Engineers Comments Regarding Surface Water Drainage

Application No: AB/135/20/OUT

Site Address: Land at Ford Road Arundel

Description of Works: Outline application with some matters reserved (except for access) for the development of 90 dwellings & associated amenity land. This application is a Departure from the Development Plan, affects the setting of listed buildings & affects the character & appearance of the Arundel Conservation Area.

Parameter Plans

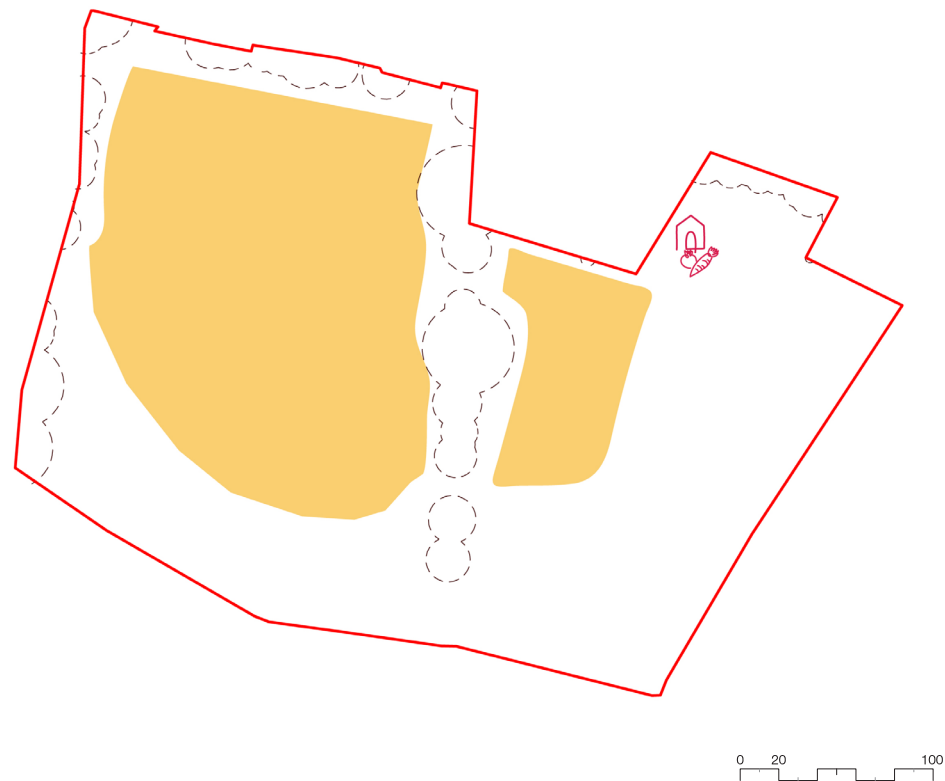
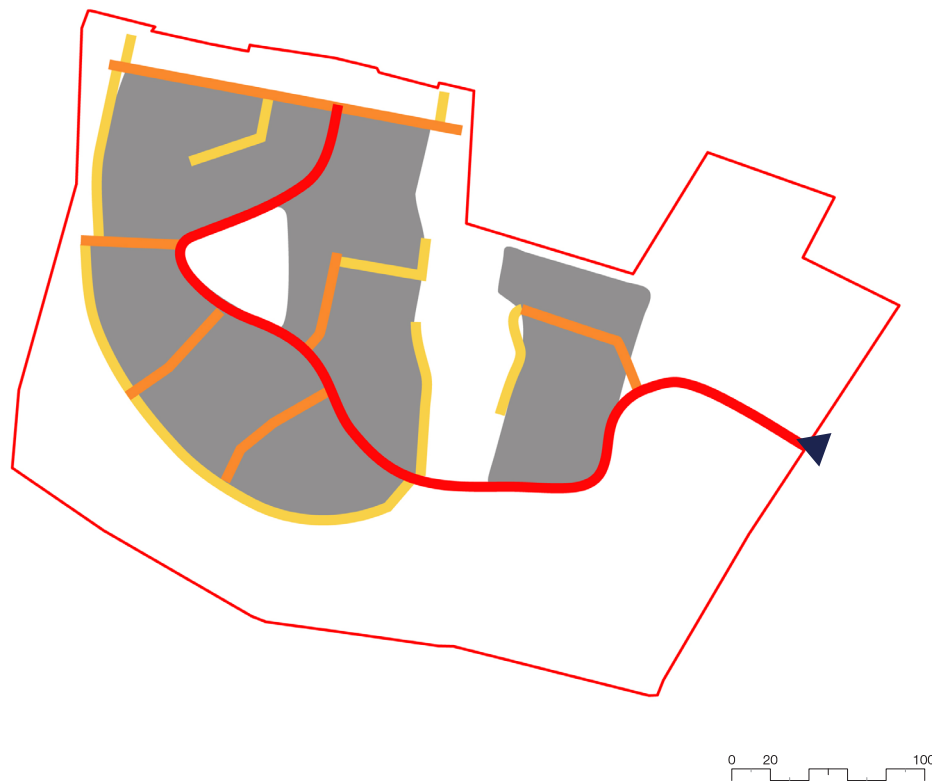
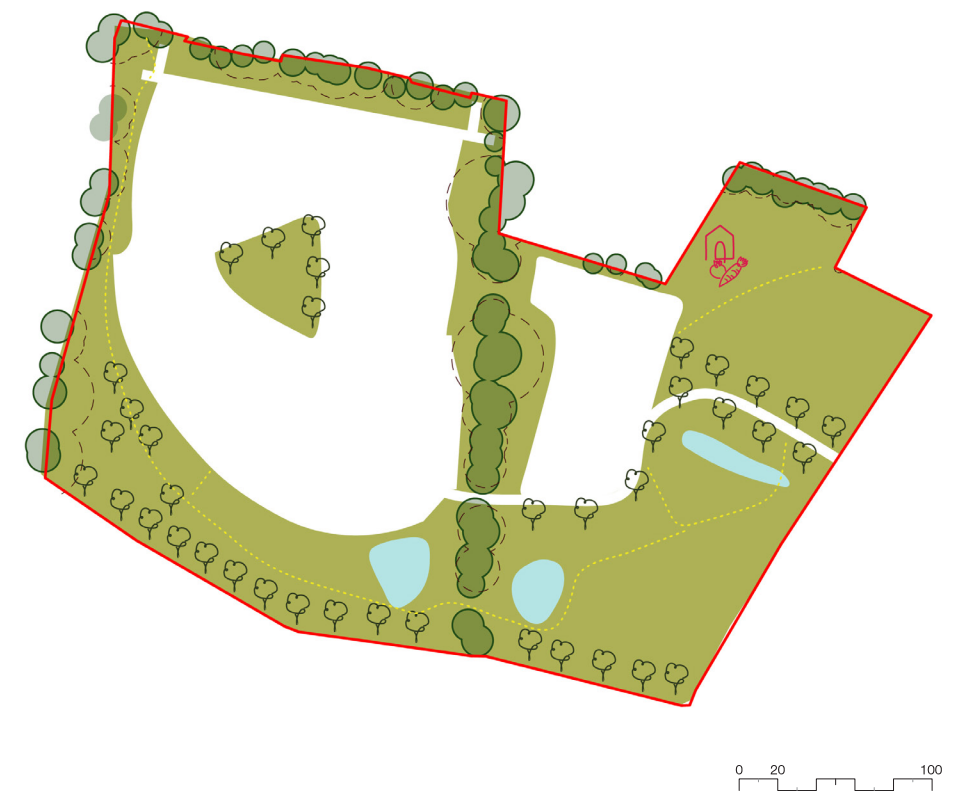
There are several ordinary watercourses that are within and bound this site. The masterplan appears to account for the majority of these watercourses. All structures, ponds, etc. must be kept at least 3m from the top of bank of any ditch. Land drainage consent will be required for any proposals to infill, culvert, divert, or modify the ditches. If it is proposed to discharge surface water to watercourse it will be required that the applicant evidences that the receiving watercourses are in an appropriate condition, some works may be required.

Surface water drainage features should also be designed in a manner that positively affects the amenity of the site. We would like to remind the developer that, open features, such as swales, basins and ponds, when designed correctly, can satisfy all the above aspirations in addition to; being easier to maintain, having longer lifespans and offering ecological advantages over subterranean features such as “plastic crate systems”.

It should also be noted that attenuation features should not be counted within useable public open space provision and must be located outside of areas at risk of flooding, e.g. flood zone 2 and 3. Adequate treatment of surface water must be ensured prior to discharge, and treatment where possible should be provided at source.

We would encourage the applicant to progress drainage proposals as early as possible. At Reserved Matters it will be necessary for the applicant to demonstrate that there is adequate space for surface water drainage within the proposed layout and that it does not conflict with other matters such as landscaping and open space provision.
